Please ask for: Ms Iqraa Malik
Email: iqraa.malik@terraquest.co.uk
Telephone: 01212341390
Our Ref: LU/253/20/HH
Your Ref:
Date: 23rd September 2020

Application for Planning Permission for Works or Extension to a Dwelling

Development: Erection of two storey side extension
Location: 33 Potters Mead Littlehampton BN17 7HY

1:500 SITE PLAN

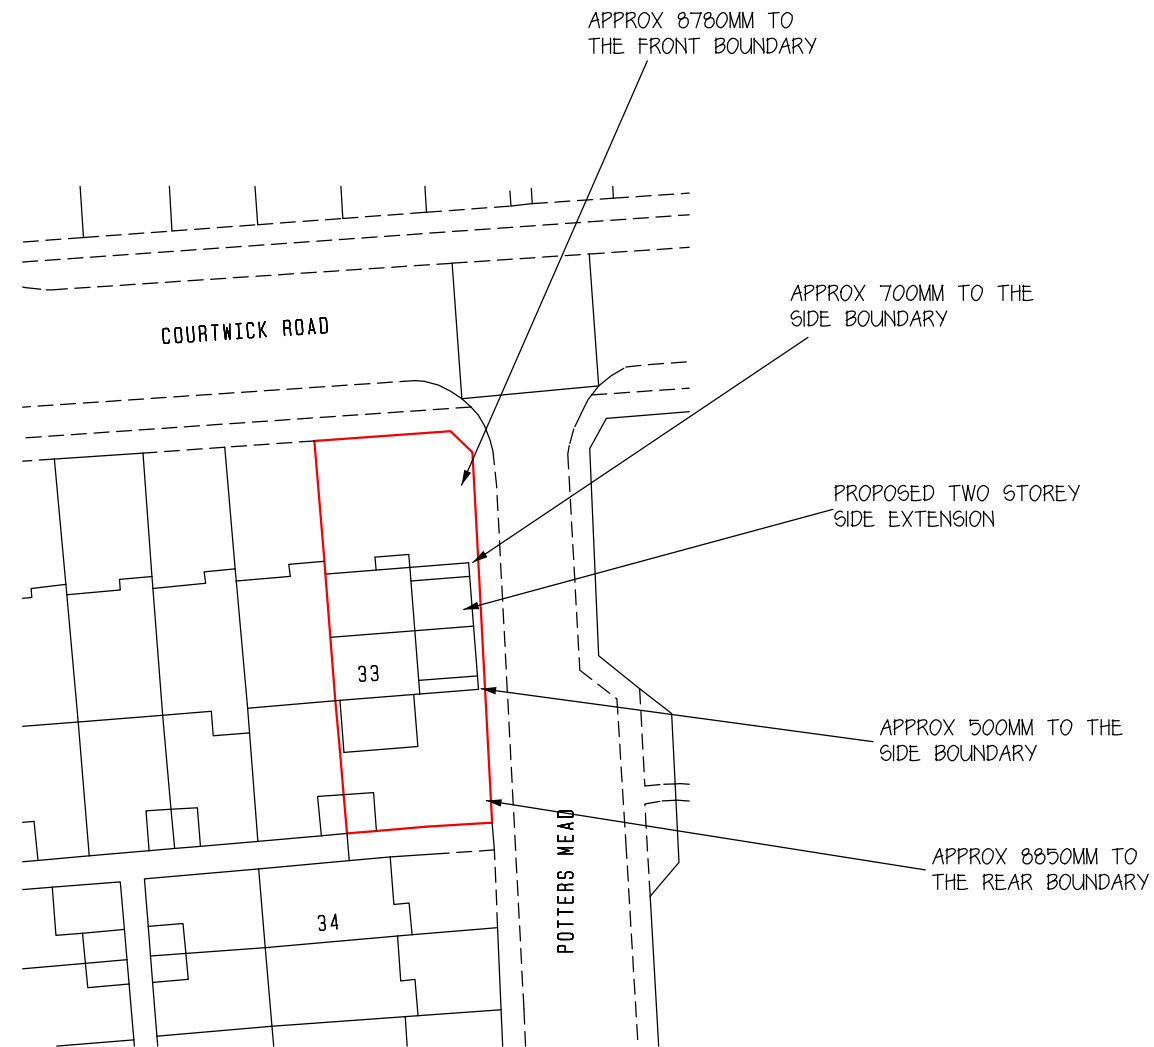
Block Plan

You are required to have dimensions from the proposed extension(s) to all site boundaries. Please amend.
